From: Ian Brewster
Sent: 23 November 2010 18:08
To: Peter Cleveland
Subject: RE: A/139/10/ Field House- Detached garage

Re: Detached garage
Field House, The thatchway, Angmering

DRG. NO. 3221/3

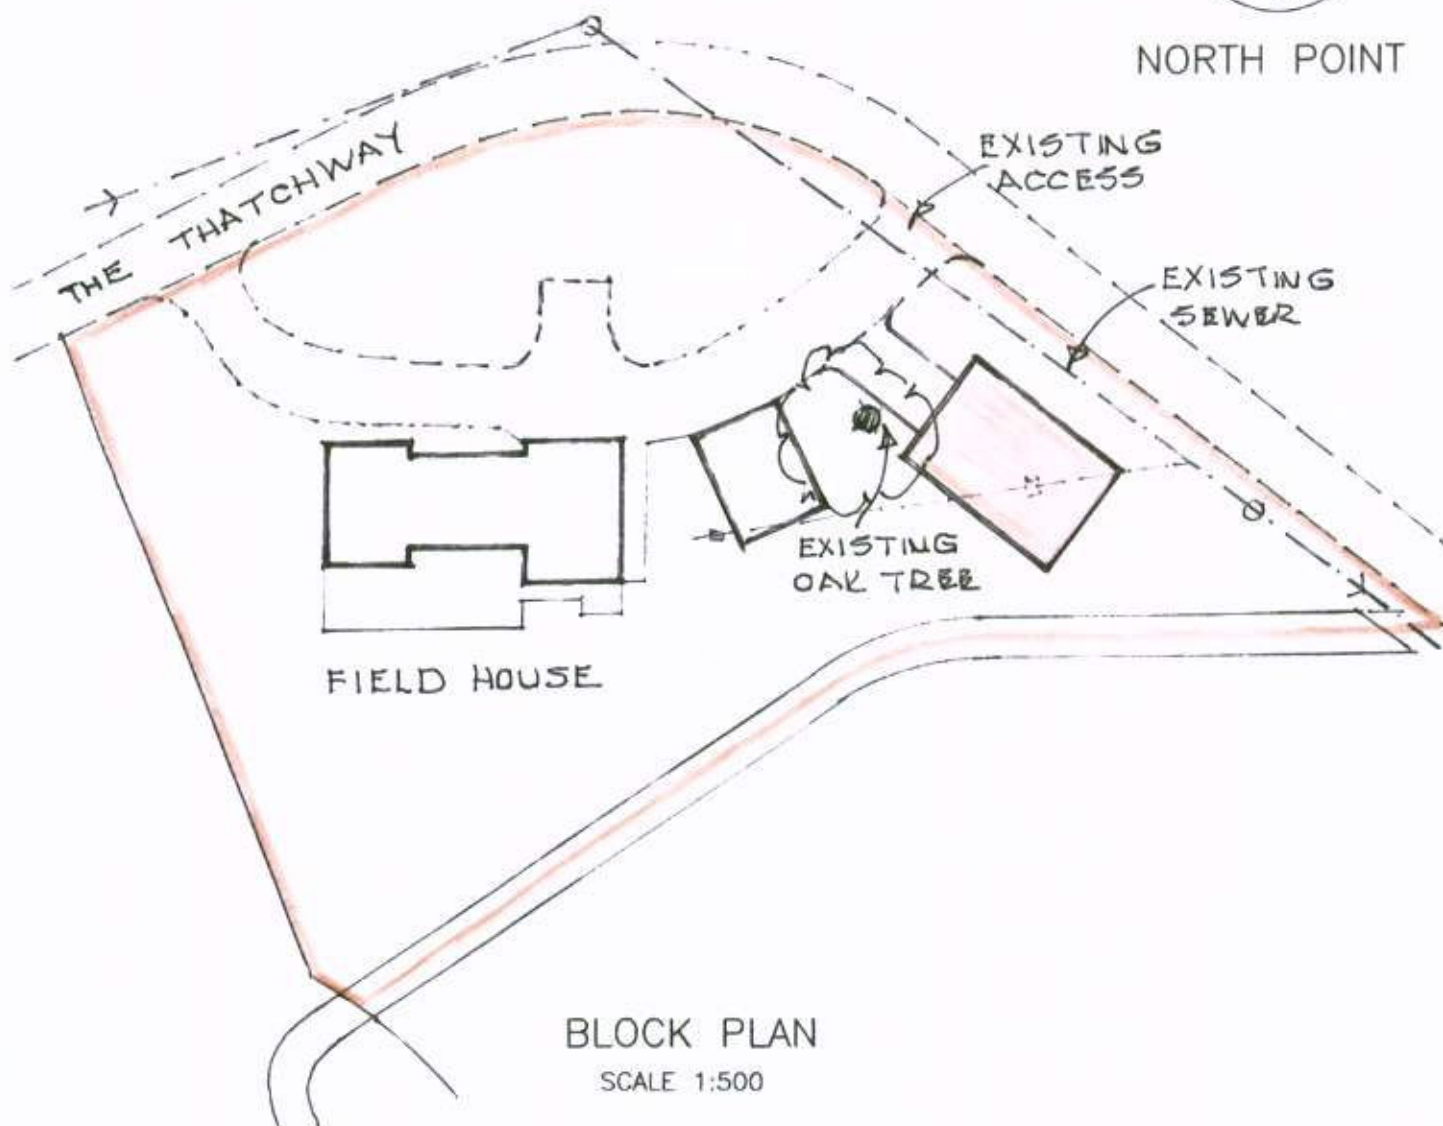
the above application refers to plans for the construction of a detached garage. The proposed development is currently to be built near to the main stem and within the crown spread of a very large and mature Turkey Oak. The Turkey Oak is protected with a Tree Preservation Order and is a prominent feature within the landscape of Angmering village and provides good visual amenity for the general public.

In this instance the garage proposal is inappropriately close to the tree and will affect upper branch spread and the underlying root structure which could adversely impact upon the health and longevity of the tree.

An arboriculturist who recognises these concerns should be employed by the applicant. The arboriculturist should suggest to the architect alternative site locations and provide a report in support of any future proposals demonstrating how this would not be detrimental to the health of good quality trees.
